Subject: Rezoning Petition Review

Rezoning Petition #: 21-285

Location of Property: Approximately 0.15 acres located in the southern quadrant of the intersection of Cleveland Ave and E Worthington Ave, east of South Blvd.

JOB NO.: 2021-119  
 DRAWN BY: MDV  
 DATE: 12.22.21  
 SCALE: 1"=10'  
**SCHEMATIC SKETCH PLAN**  
**RZ.1**

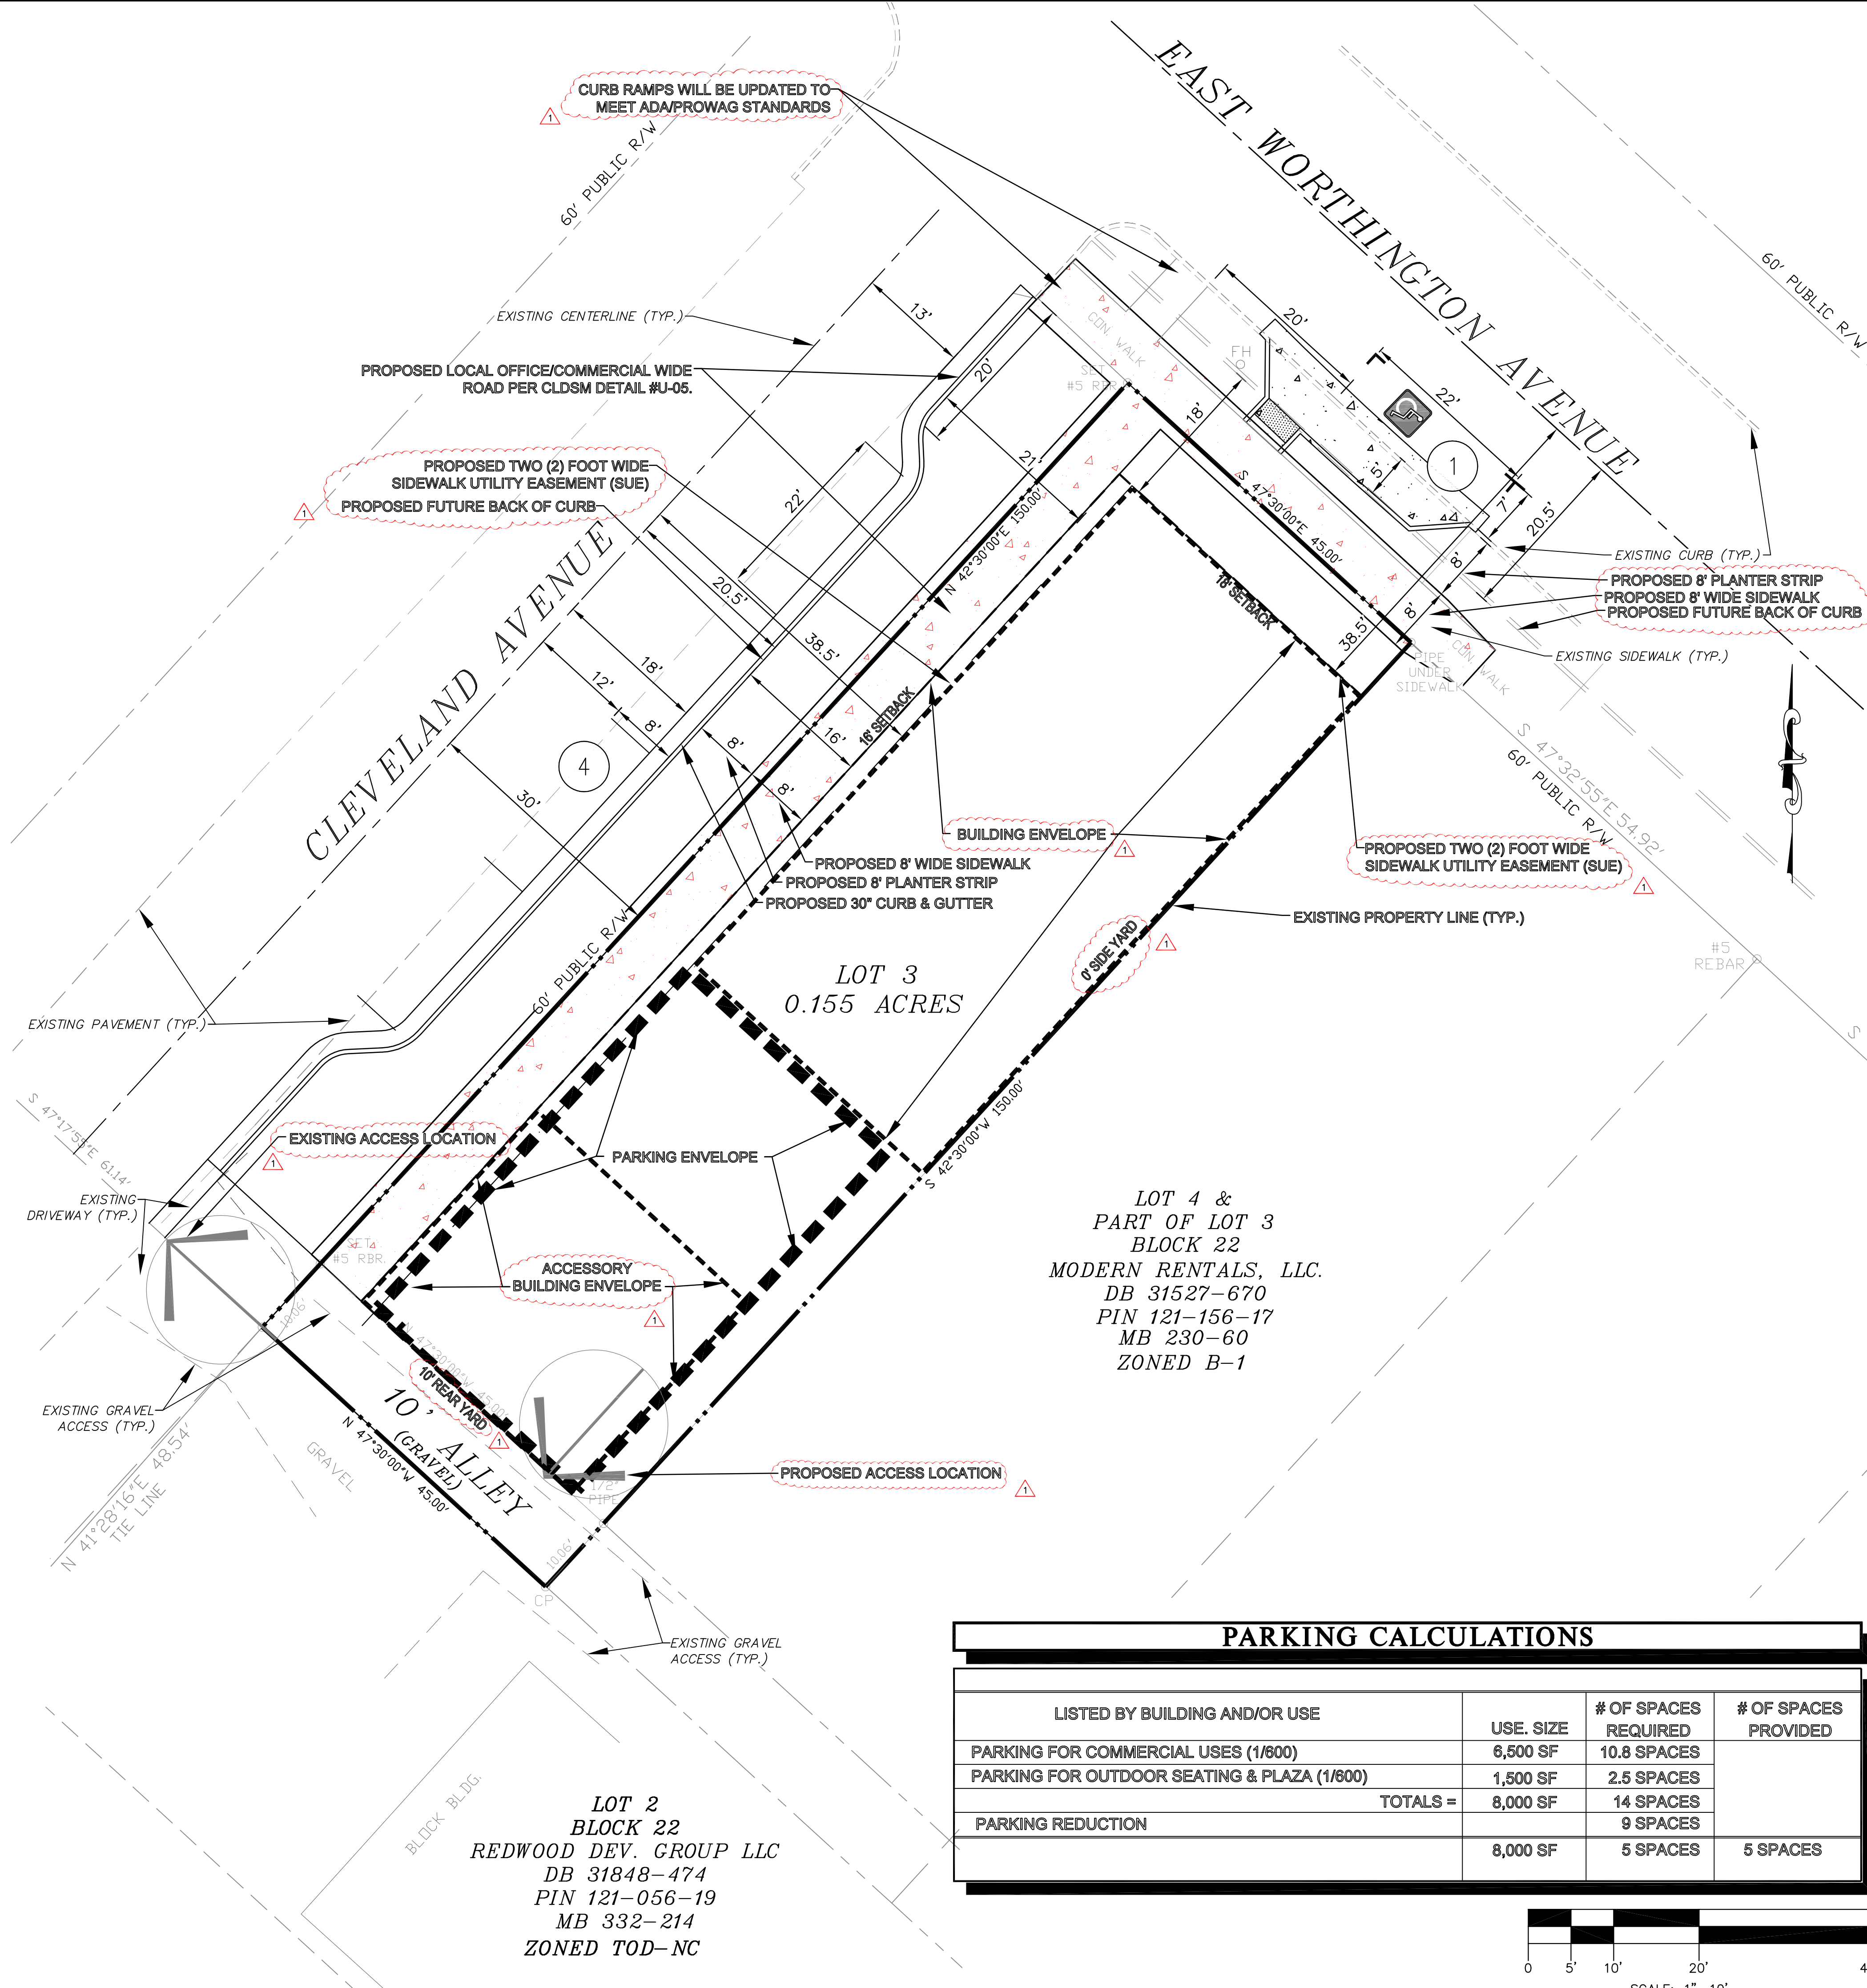
PCSO compliance is not determined during the rezoning process. Please remove the following sentence from note VI.1 under "Environmental Features": *Site work already completed prior to this rezoning plan shall be deemed in compliance.*
